Colorado Department of Transportation  
Arthur Gonzales  
R2 – Access Manager  
RE: Meadowlake Ranch Sketch Plan\_EA17227\_SKP184 – Revised Addition of  
Hydraulic Review

Per your review dated 2/28/19 for Meadowlake Ranch MDDP, we offer the following responses to your comments.

Meadowlake Ranch Pond/Wetland Areas

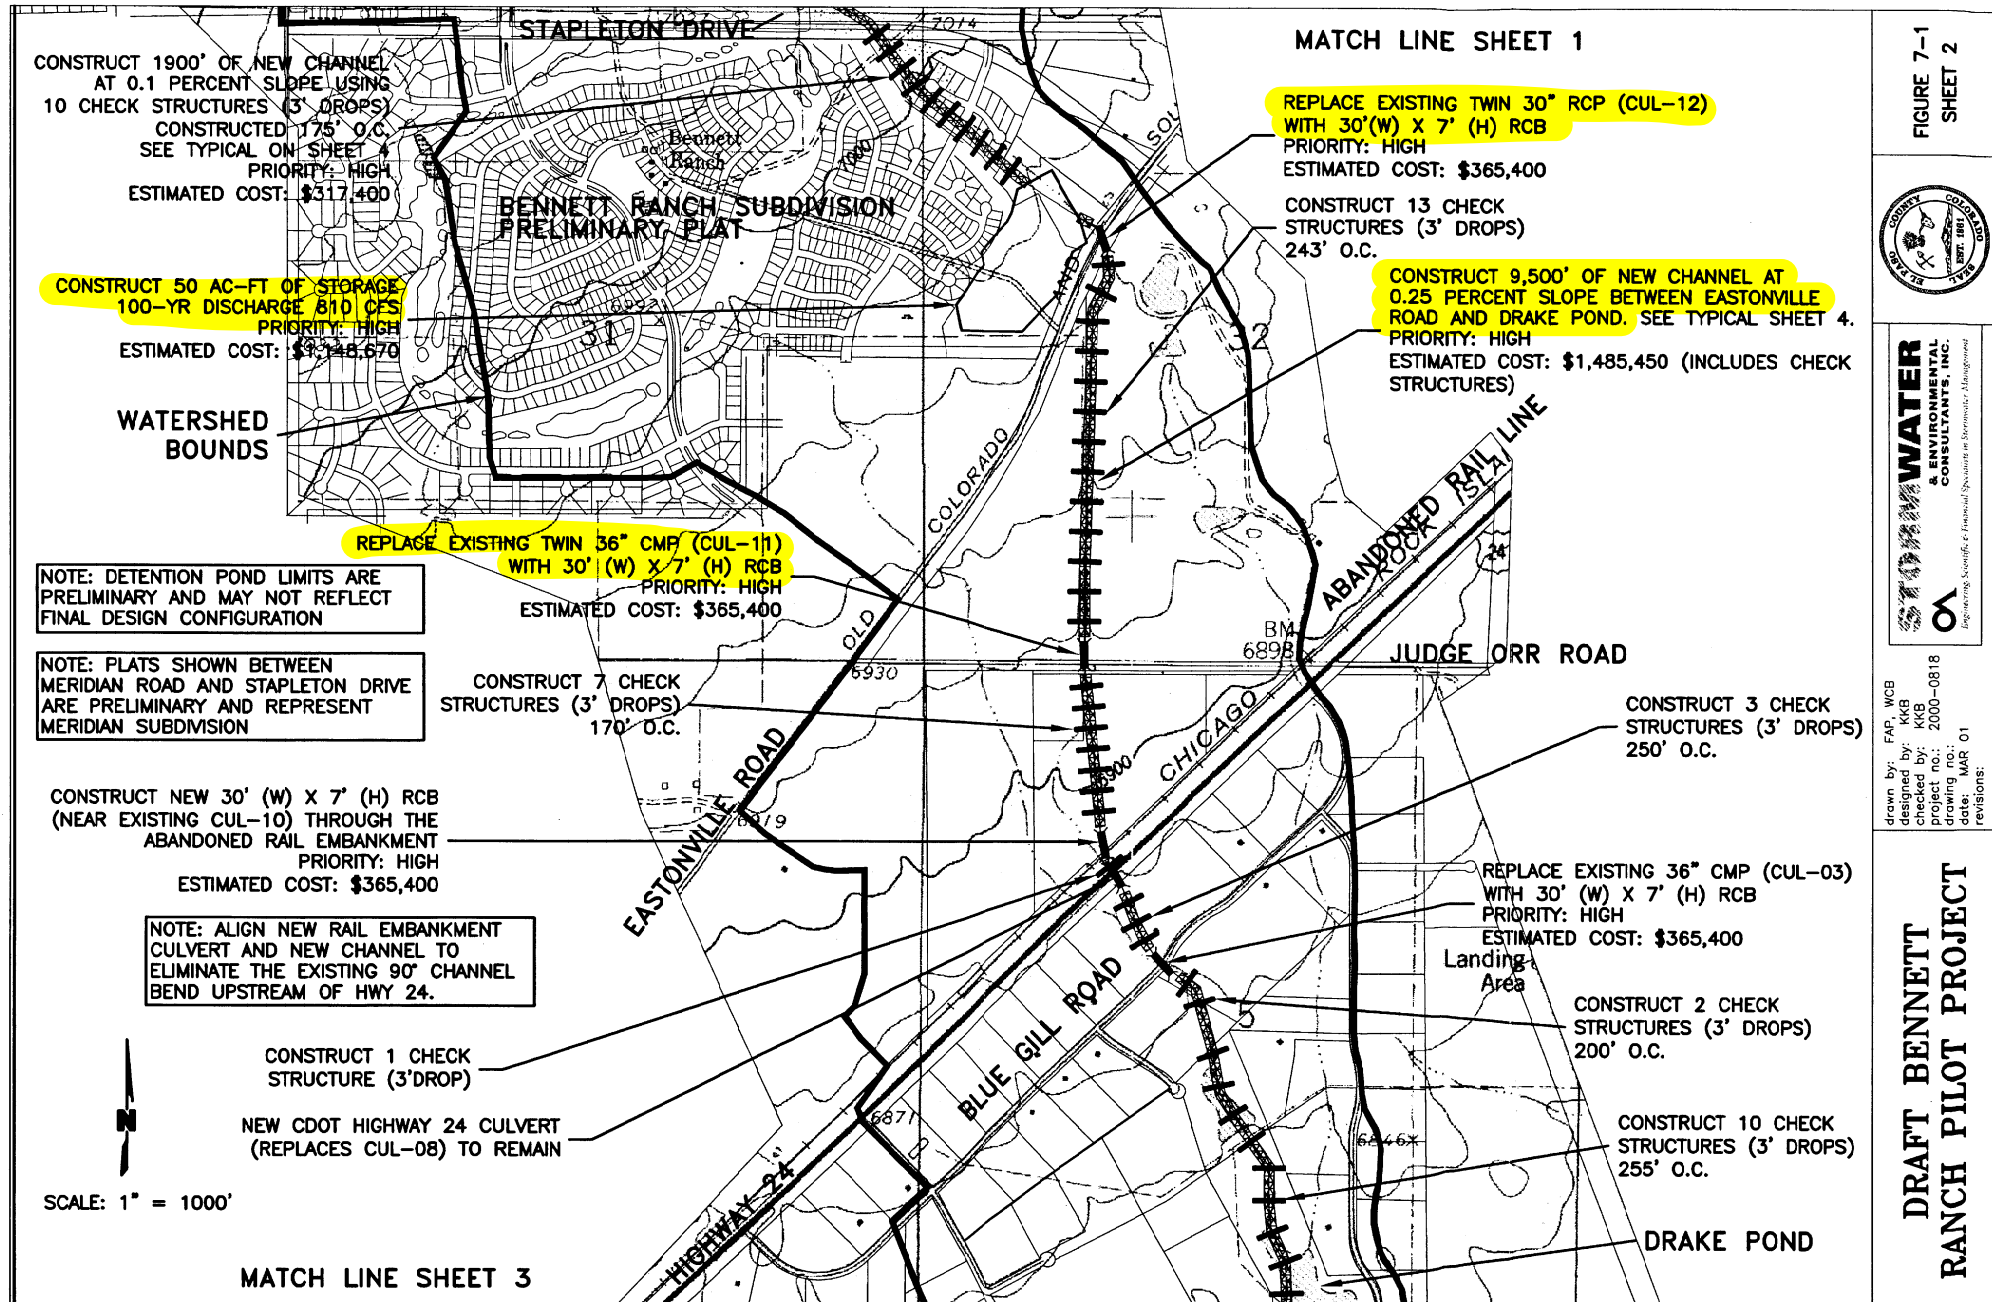
**Comment b. Page 7:** *Prove that this area doesn't contribute to downstream flows. Seems odd to eliminate basin area from analysis, especially since there is evidence of flows downstream of these wetland areas (natural swale, 24" CMP culvert under Judge Orr). Please show proof that this area can be removed from the hydrology.*

**Response:** The flow that crosses under Judge Orr Road downstream of the wetlands/ponds area comes from the drainage basin west of the wetlands/ponds. The ponds do not have outlet structures and the berms are vegetated and stable. El Paso County requested additional analysis of this area and a revised MDDP was submitted in early March. Below is the discussion from the revised report.

The existing ponds/wetlands area will remain as part of an open space area for the proposed development. This location was analyzed by dividing the wetland area into three basins (WP-A, WP-B, and WP-C) according to the three major areas of standing water (see Exhibit in Appendix) and determining the runoff volumes for the developed 100 year event. The 100 yr developed runoff volumes are as follows: WP-A = 4.0 ac-ft, WP-B = 5.8 ac-ft, and WP-C = 1.6 ac-ft. To retain these ponds/wetlands in the future development, these runoff volumes should be multiplied by the appropriate safety factor and the berms re-graded to provide adequate storage above the pond-full elevation plus freeboard. Calculations for the runoff volumes are included with the Exhibit in the Appendix. The ponds and spillways to remain will be evaluated for safety/stability by a geotechnical engineer. The appropriate hydrologic, hydraulic, and geotechnical analyses for this area must be included in the future Drainage Report.

Single 24" Pipe Culvert under Judge Orr Road (Design Point 1)
 Q5= 4.0 cfs, Q100= 29.1 cfs
 Projecting End

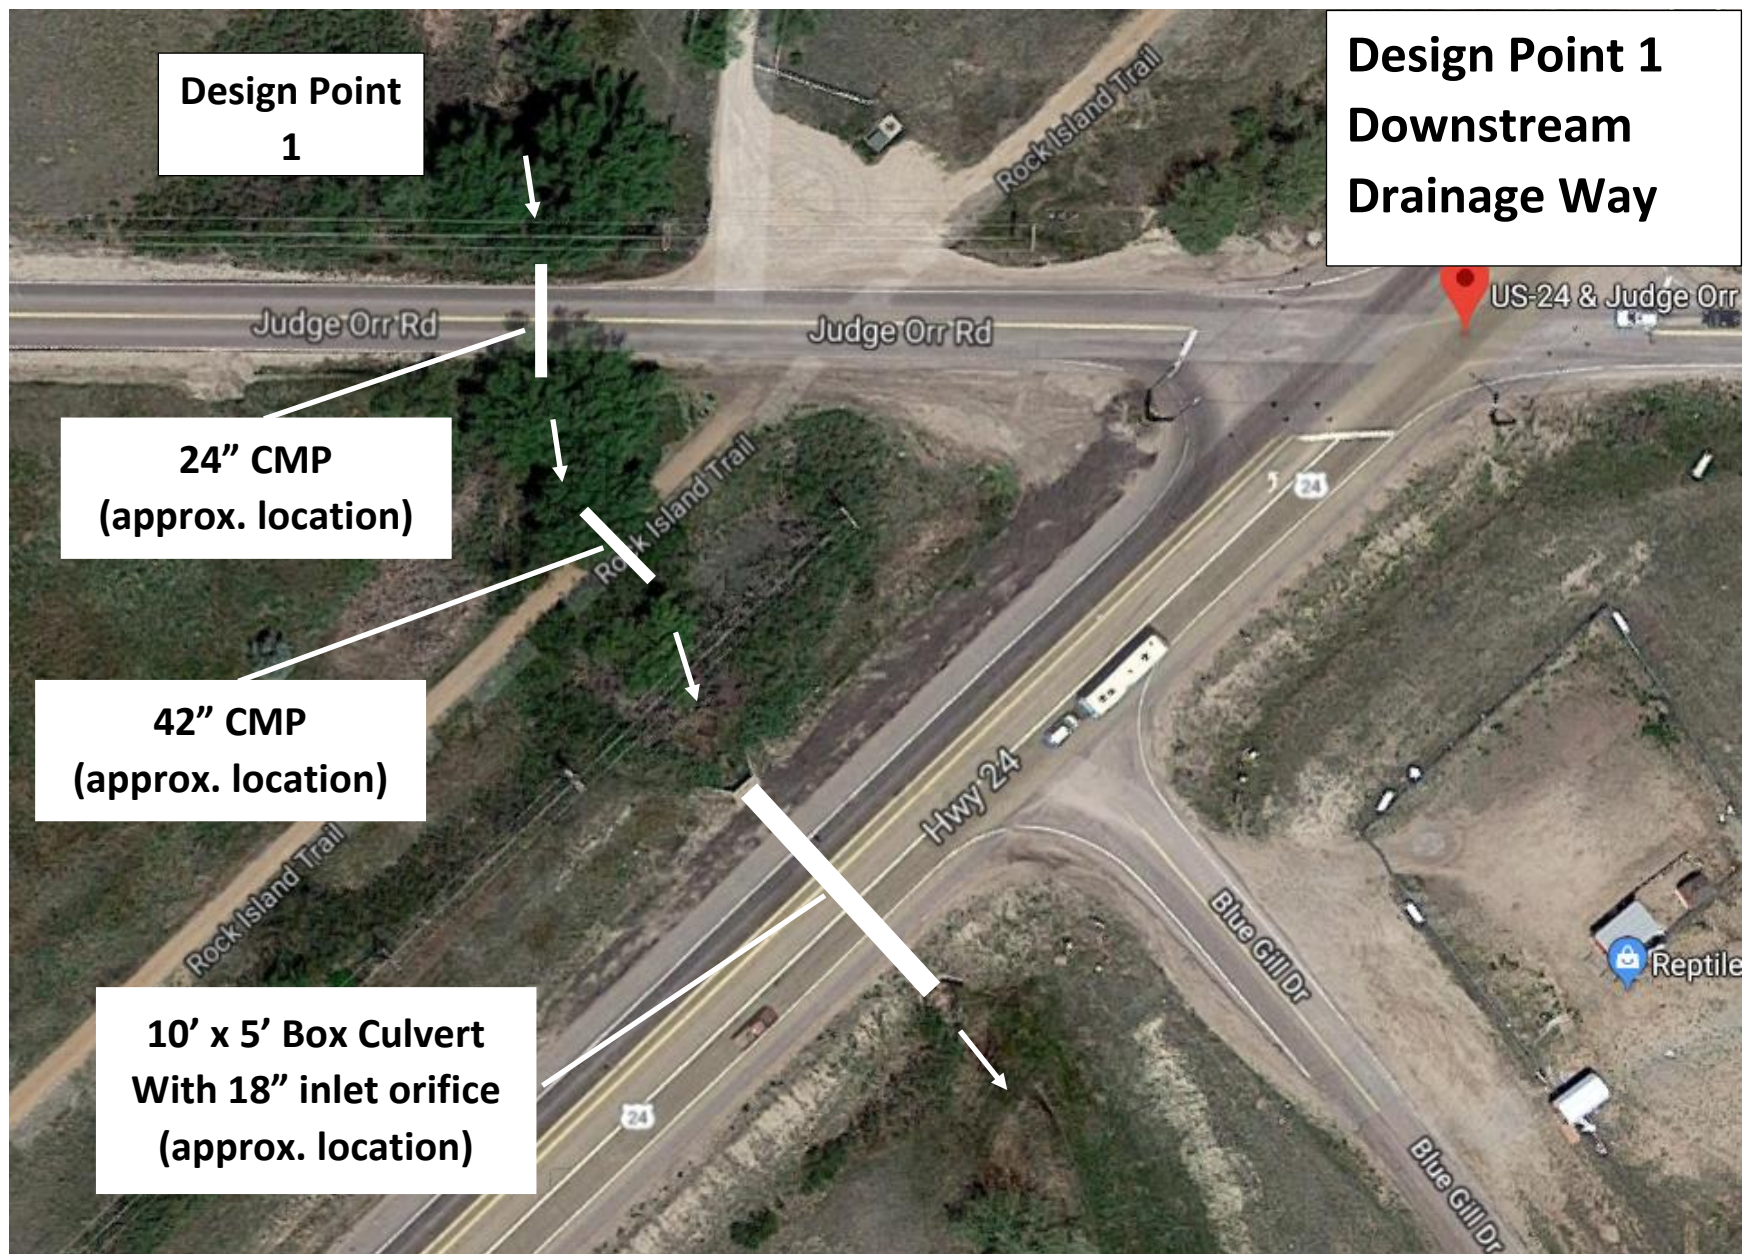
**Comment c. Page 8:** *Tributary area and runoff discharge should include the 63 acre wetland basin. This will require improvements downstream. However, this outfall seems to have been analyzed already, and recorded with FEMA. See attached FIRM map, effective December 7, 2018. Please update discussion of this basin.*

**Response:** As discussed above, the wetland/pond area will be retained in the proposed development and the berms regraded to attain the required runoff storage. The exact storage will depend on the development details, which are unknown at this time. The FIRM will be updated in the MDDP. The MDDP addresses the need for a detailed analysis of the Judge Orr Rd crossing, but such an analysis will be addressed in a future Drainage Report. The pertinent portion of the MDDP is included below.

The headwater to depth ratio for a 24" pipe under inlet control is  $HW/D = 0.6$  for the 5 year event and  $HW/D = 3.0$  for the 100 year event (see Exhibit in the Appendices). At  $HW/D = 3.0$ , Judge Orr Road would be overtopped. Therefore, the 24" pipe culvert may need to be upgraded. However, the downstream drainage way for Design Point 1 will need to be further studied in future Drainage Reports to assess the impact to Design Point 1 because just downstream of Judge Orr Rd the flow goes east under Rock Island Trail via a 42" CMP and into the ditch area between the trail and State Highway 24. The flow then passing southeast under Highway 24 is restricted by an 18" opening on the inlet end of a 10'x5' box culvert. Presumably, the runoff would pond between the State Highway 24 and Rock Island Trail, as well as the area between Rock Island Trail and Judge Orr Road. Potentially, the ponding could also extend to the north side of Judge Orr Road.
